From: Martyn White <Martyn.White@arun.gov.uk>
Sent: 21 July 2021 10:44
To: Planning.Responses <Planning.Responses@arun.gov.uk>
Cc: Simon Davis <Simon.Davis@arun.gov.uk>
Subject: Y/71/21/OUT

Y/71/21/OUT

Land At Little Meadow And East Of Bilsham Road Yapton BN18 0JY

Figure 3.2 - Proposed General Development Layout

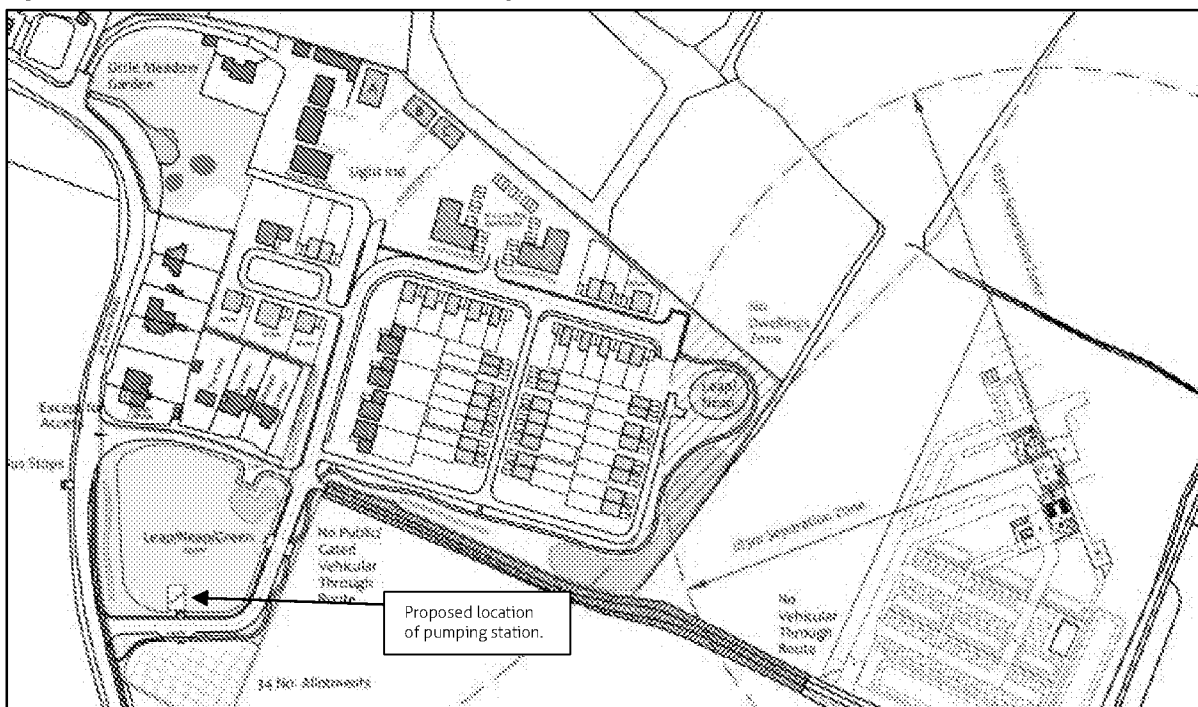
Whilst the illustrated layout indicates that the existing/proposed vegetation would attempt to buffer the development from the closest listed and locally listed buildings, the development would still affect the area around which the buildings are experienced, which could be harmful. The proposal would represent a substantial increase in the number of dwellings in the hamlet and would be out of character. Any development of this scale in this location would also not reflect the linear, piecemeal development which is a clear element of the character of the hamlet. It is also assumed that development of this site would take the form of an average housing estate consisting of a mixture of standard house designs which are not found in the hamlet. This impact would be enhanced through the choice of layout and provision of other C20 features, such as lighting, junctions and pavements.

Based on a review of the illustrative layout it would appear that the location of the proposed formal open space and new junction would also be visible on entrance/exit of the hamlet, further affecting the existing character. Ultimately, such a development would suburbanise the area and erode the semi-rural character.

It is also considered that the provision of any new pathways alongside Bilsham Road (in full or part) will further suburbanise the hamlet, which at present does not feature excessive amounts of standard paving.
